Date: 13 December 2022

**Application by Drax Power Limited for an Order Granting Development Consent for  
the Drax Bioenergy with Carbon Capture and Storage Project**

**Procedural Decision following request to make changes to the application**

DRAWING NUMBER
 EN010120-PA-LP-8.5.3.9-Sheet2

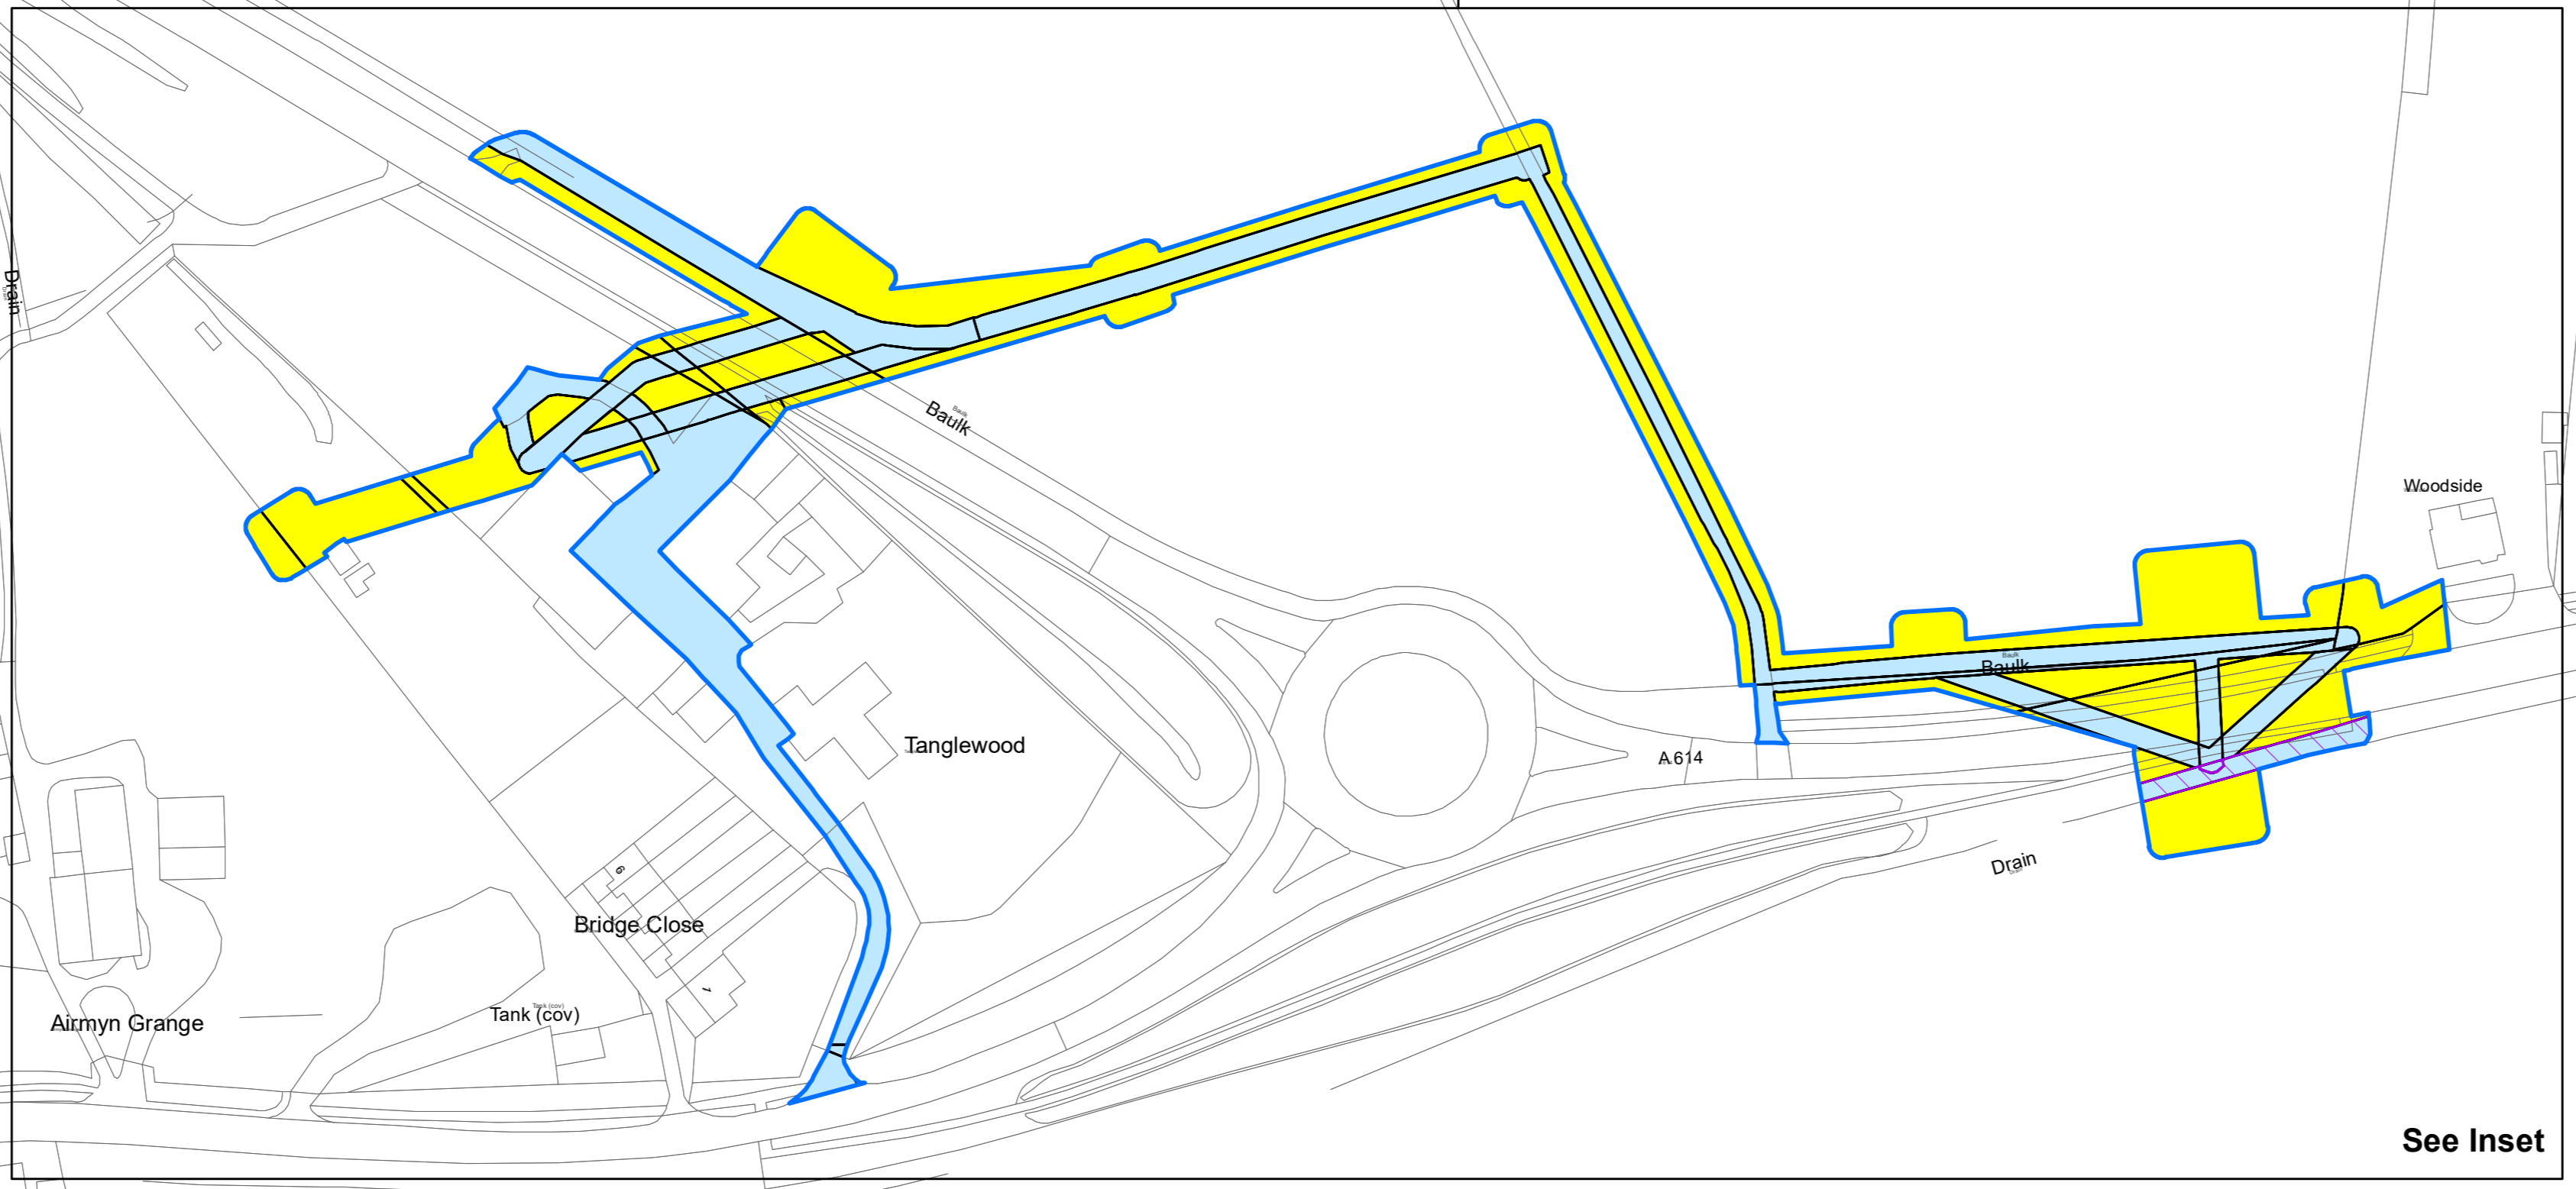
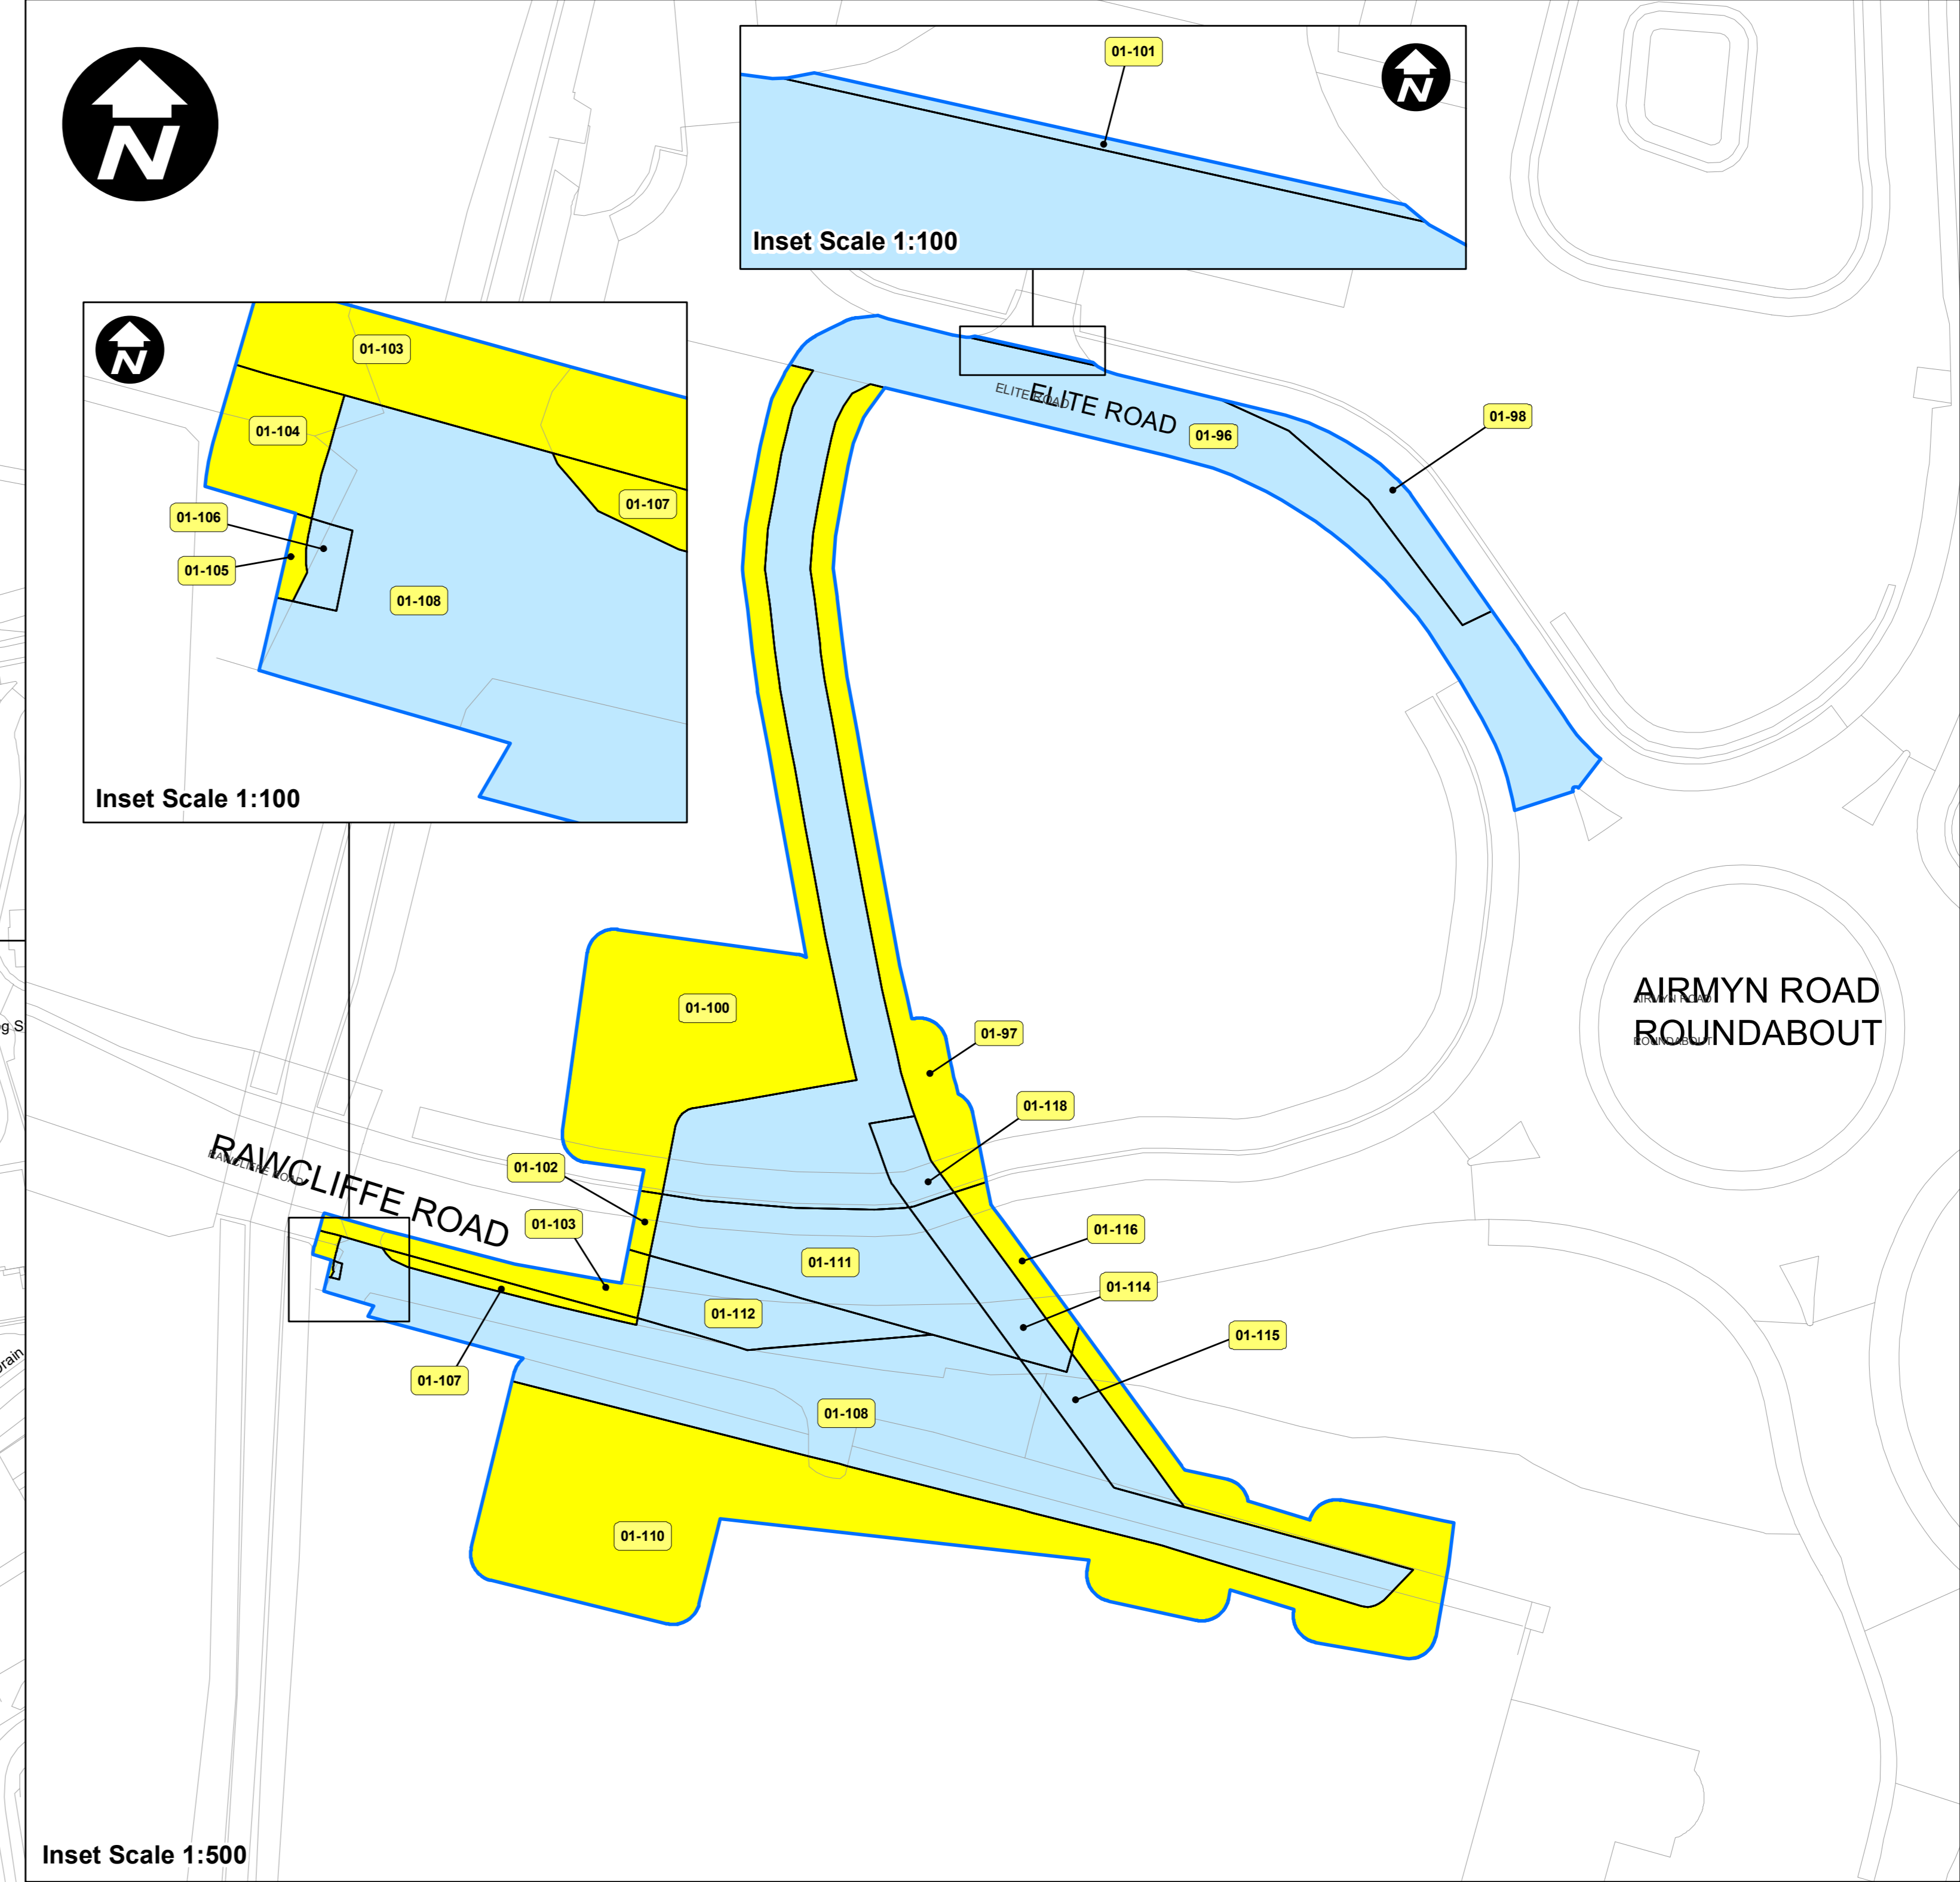
In reviewing the submissions for the change request, the ExA has made some observations on the Land Plans and Work Plans and would ask the Applicant to review and consider the below prior to the submission of its consolidated updates on 3 January 2022:

- Plots 01-82 and 01-92 on the Land Plans each appear to comprise two distinct sub-plots. Should each of these apparent sub-plots be individually numbered as a separate plot?
- Please provide an insert of 01-55 on the Land Plans for clarity.
- Should plots 01-47, 01-78, 01-80, 01-114 and 01-115 on the Land Plans be shaded green?
- Please ensure that a Key Plan in accordance with Regulation 5(4) of the Infrastructure Planning (Applications: Prescribed Forms and Procedure) Regulations 2009 is submitted with the updated Land Plans, as this is omitted from the Land Plans submitted with change request.
- Should centre lines be shown for Work No. 8 on the Works Plans given it relates to overhead lines?
